## PLANNING CONSULTATION RESPONSE

<b>Application No</b>	2026/0034
<b>Proposal</b>	Outline application for the erection of one dwelling with details of access and layout (other matters reserved).
<b>Address</b>	Land to the West of Chapel Road, Pilley, Barnsley, S75 3AR
<b>Date of Consultation Reply</b>	13/2/26
<b>Consultee</b>	Highways Development Control

**SITE PLAN**  
SCALE 1:100

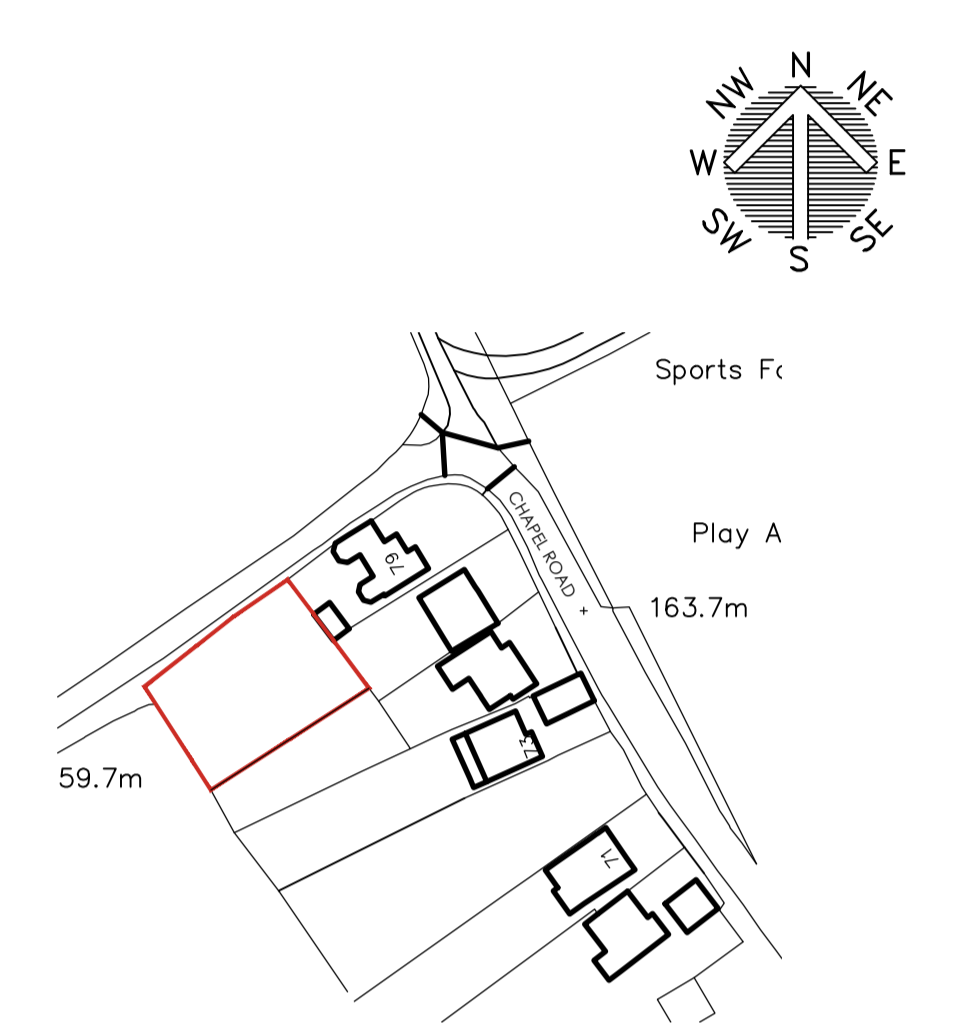
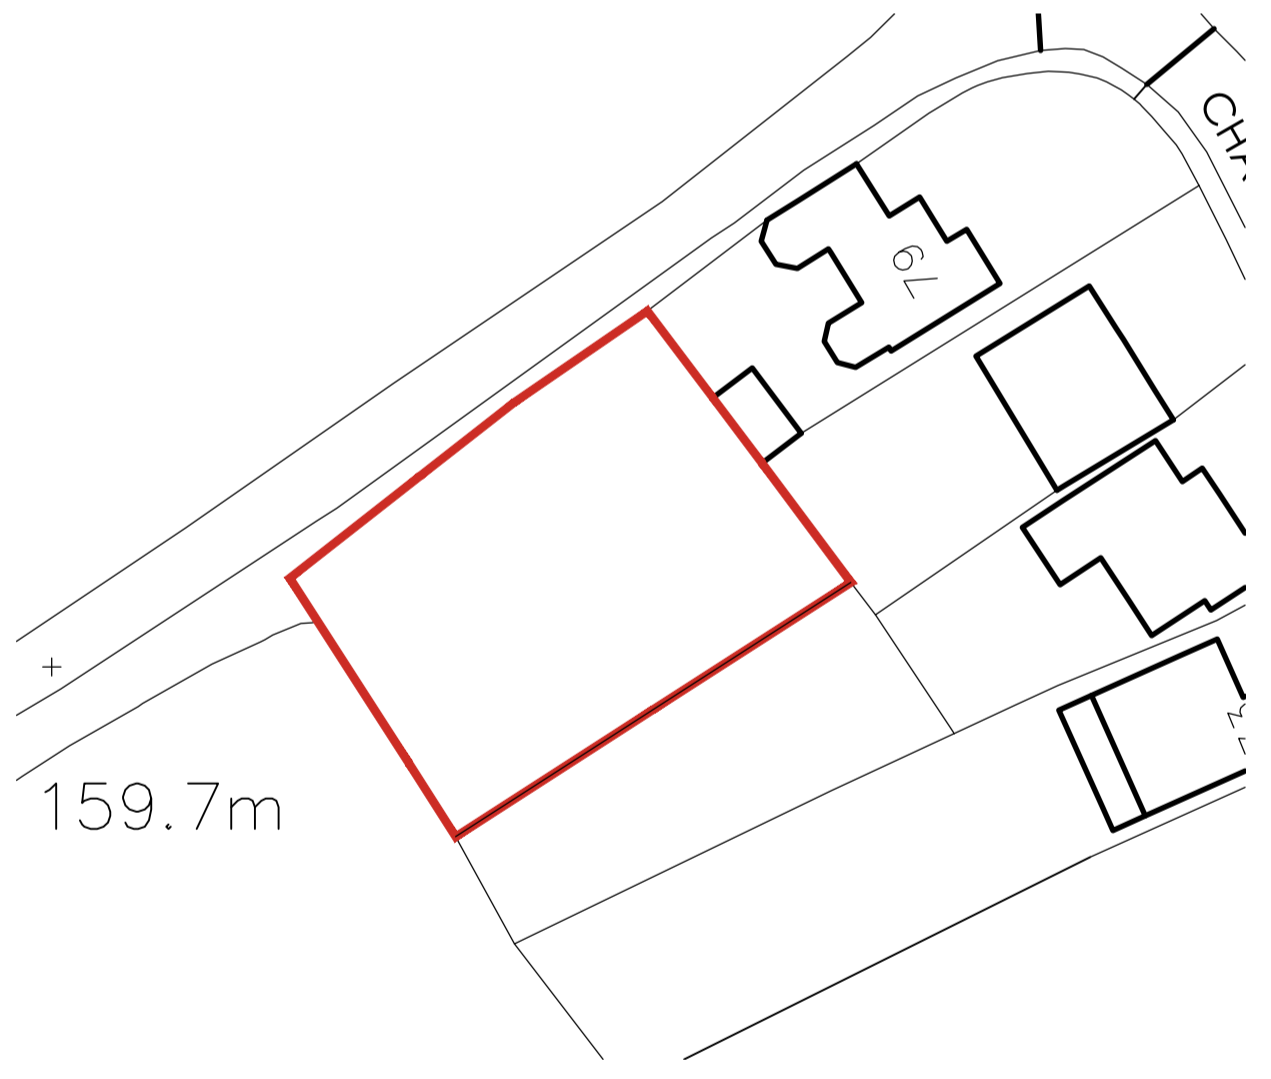
Whilst I do not object to the principle of the proposal for a single residential dwelling on this land, I would ask that a site plan showing the minimum required visibility splays at the access, together with vehicle tracking to ensure vehicles can turn within the site is provided.
